**Consultation Response from KC,
Conservation & Design**

2026/91339 Slaithwaite Railway Viaduct, Nabbs Lane, Slaithwaite, Huddersfield

**Listed Building Consent for installation of five overhead electric line equipment portals on piers 3, 7 and 11 with supporting wall brackets; tubular handrail to replace existing on span over Bank Gate; new downpipes on same piers connected to existing outflow pipes.
Reinforcement of the north parapet with precast concrete L units, and rebuilding north side of eastern terminating span over Bank Gate, including replacement of bridge deck, parapet, and reconstruction of flanking pilasters (within a Conservation Area)**

Date Responded: 13/8/26

Listed Building Consent
Drawing - MVL3/61 Slaiithwaite
Viaduct - Proposed Plan
and Elevations

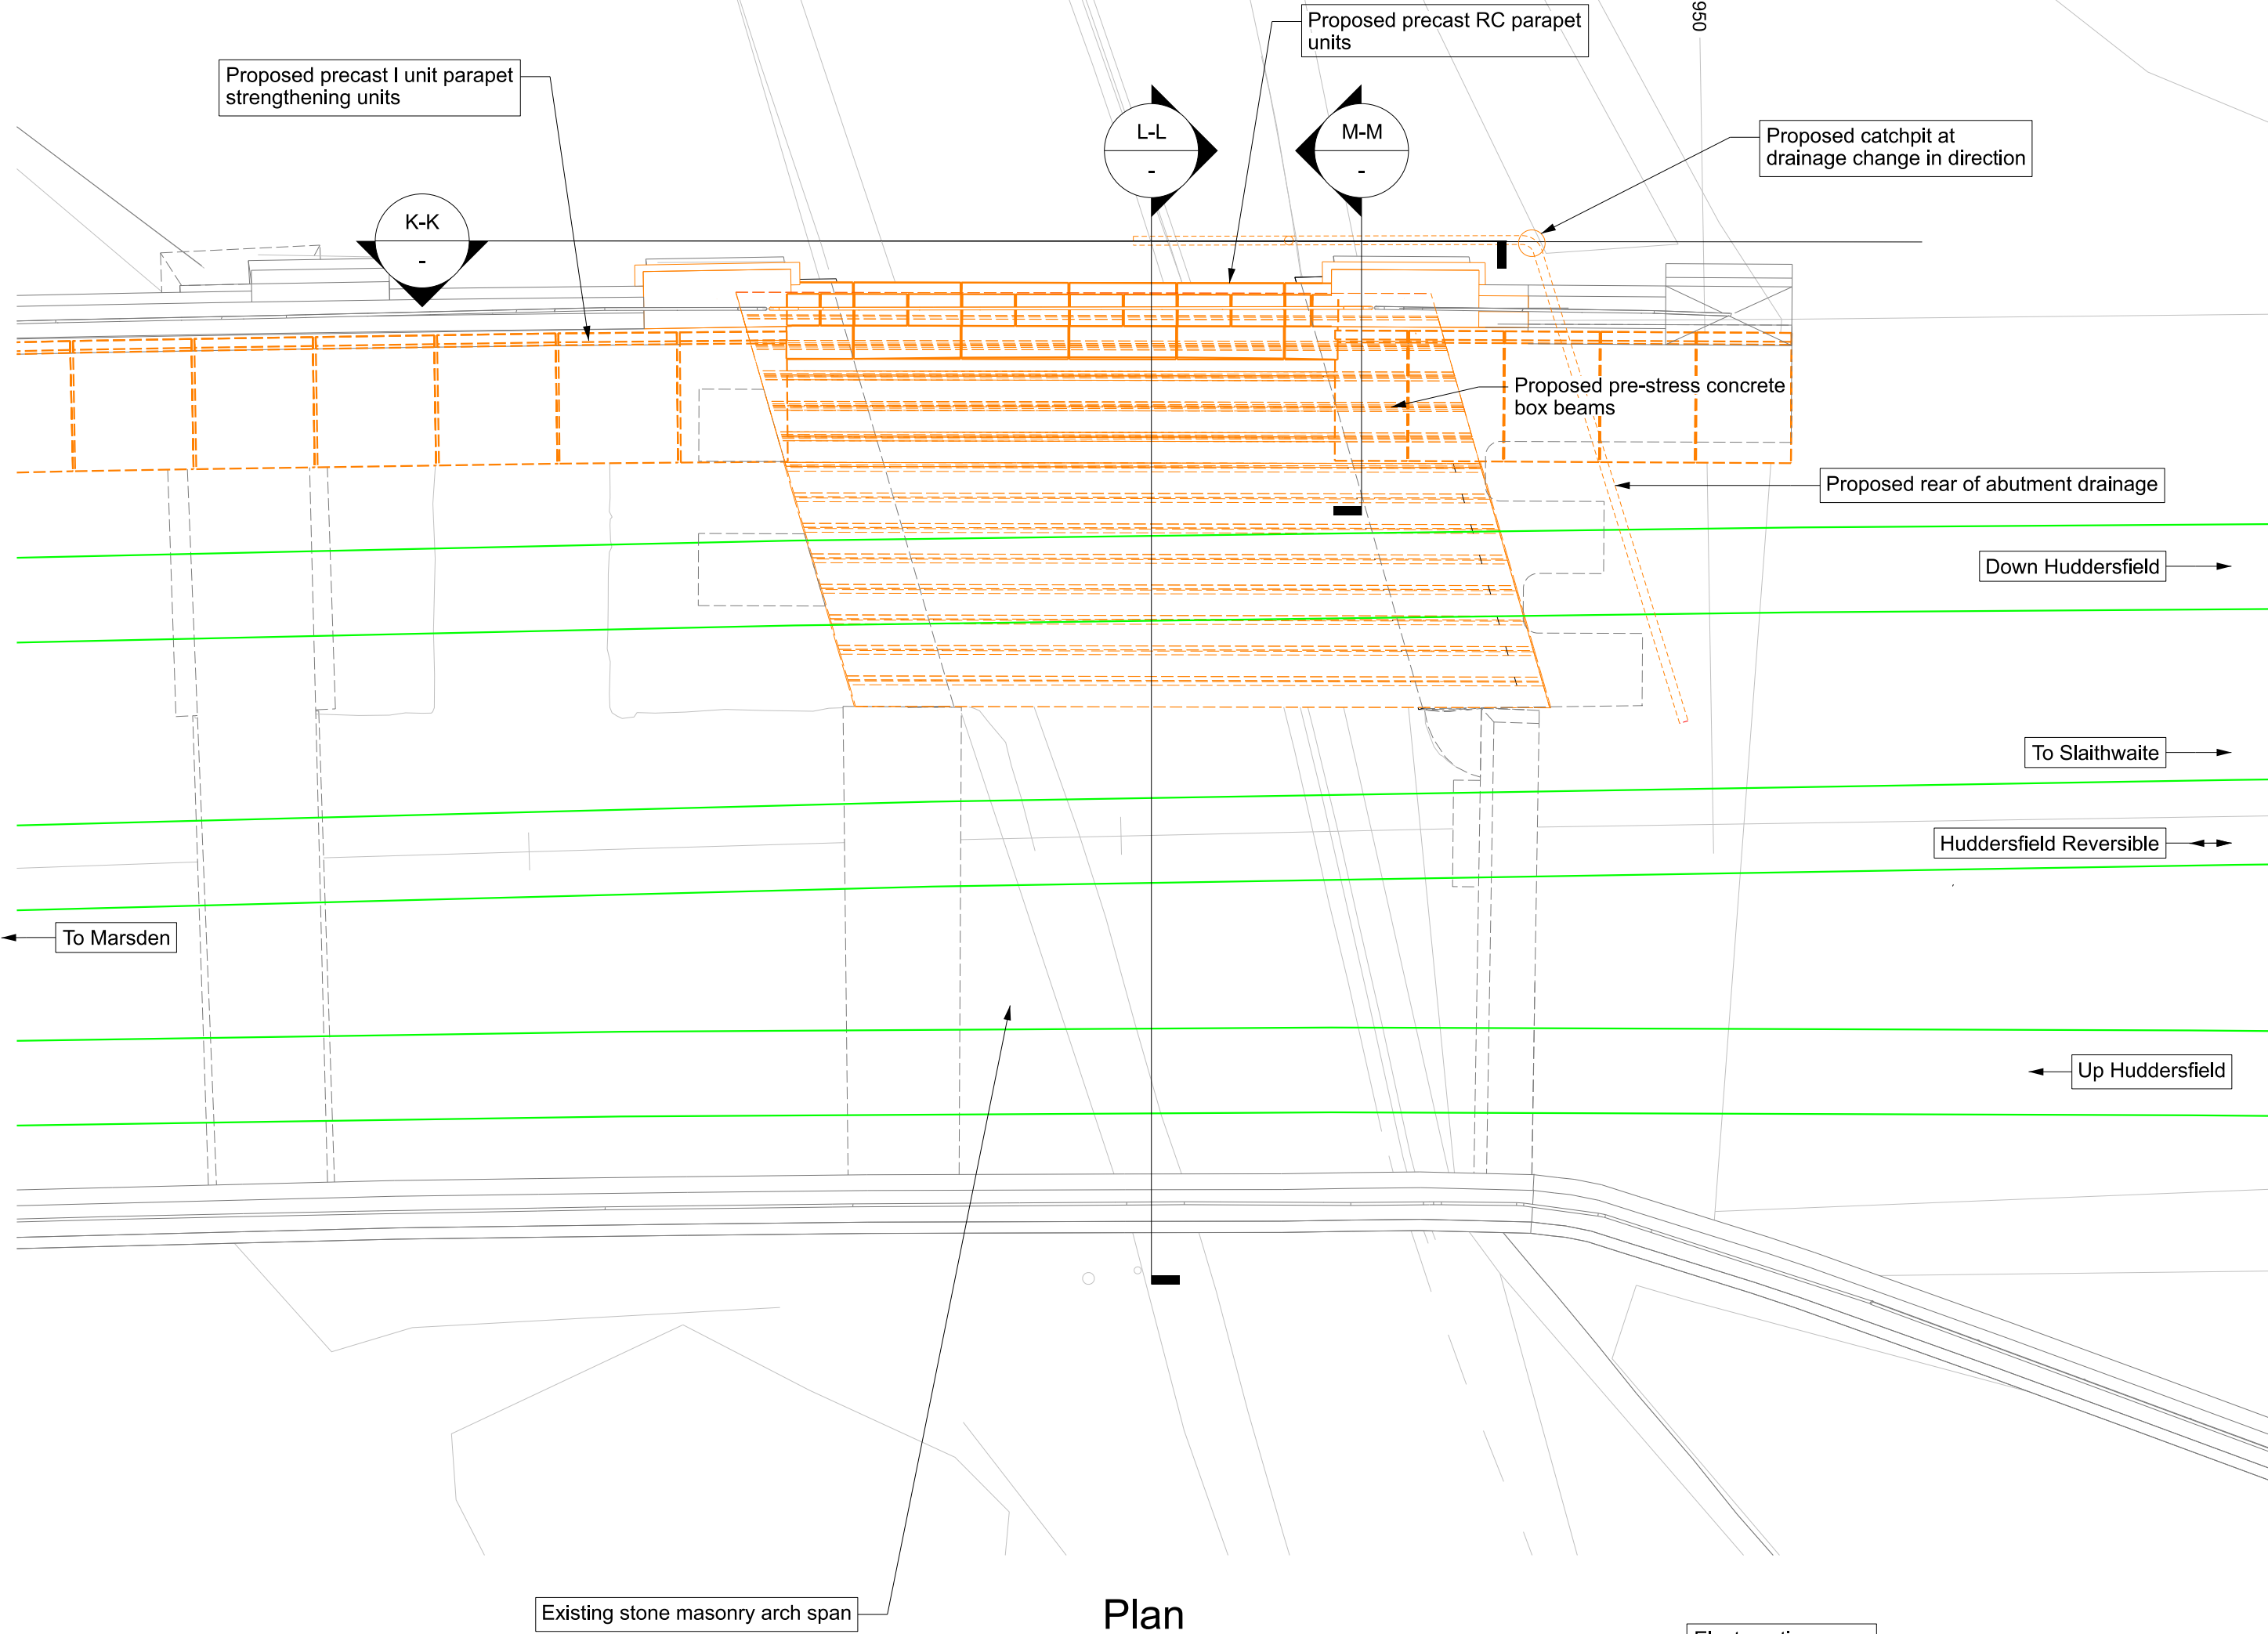
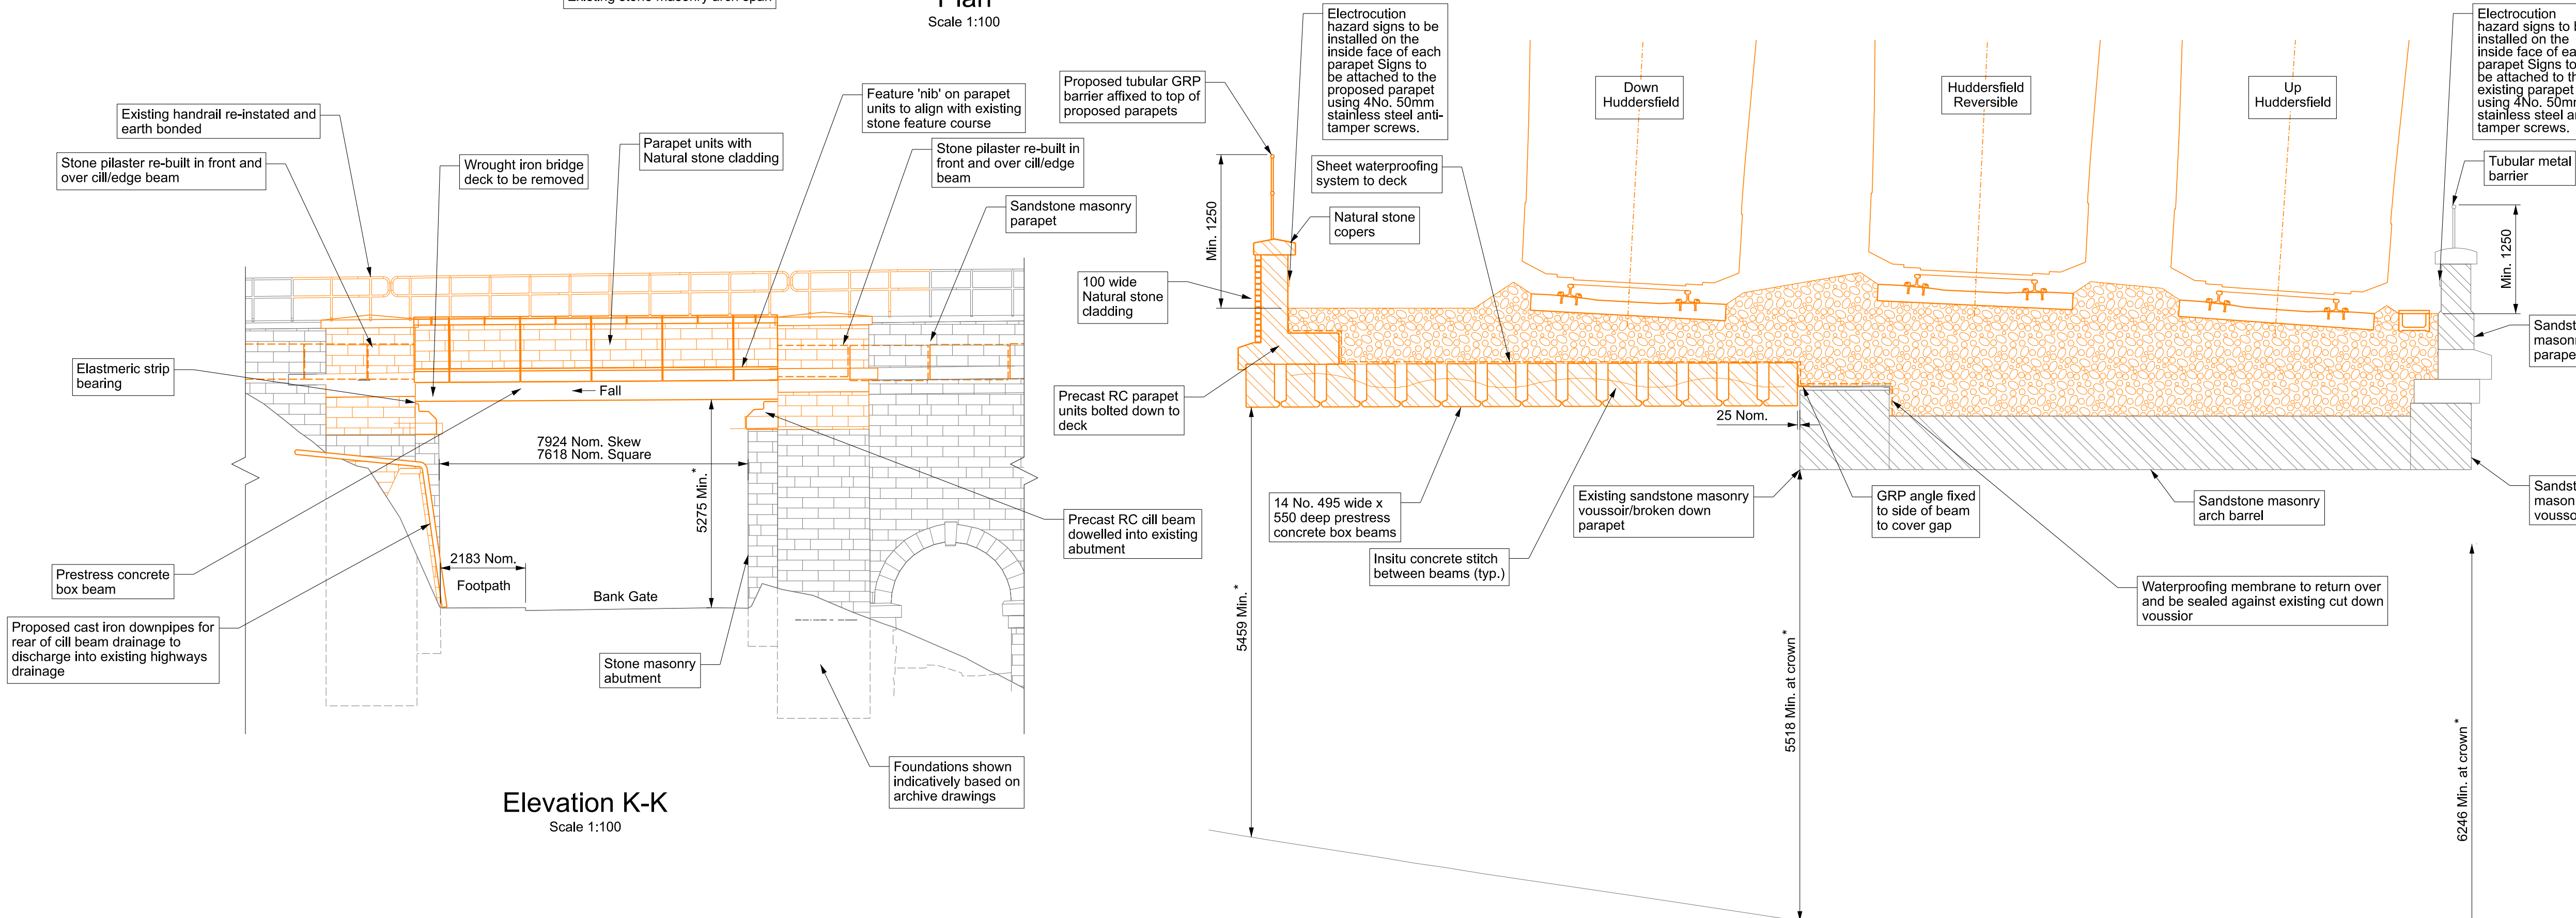
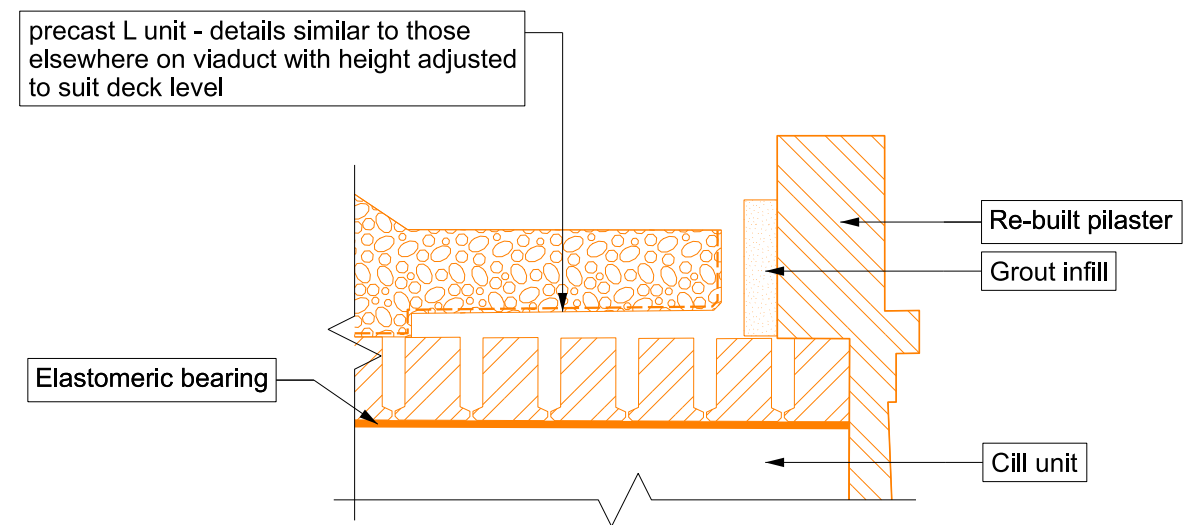
The detailing and finish of the alterations over Bank Gate will largely replicate the existing stonemasonry finish through the use of natural stone cladding to the external (north) side of the precast reinforced concrete parapet units. The replacement of the existing wrought iron bridge deck with the use of natural stone cladding is preferred to the use of concrete artificial stone cladding. It is requested that the concrete box beam should be through-coloured concrete with a beige/buff/stone colour to match the adjacent stone.

5. New concrete box beam to be through-coloured buff/beige/stone colour to match the adjacent stone as closely as possible.
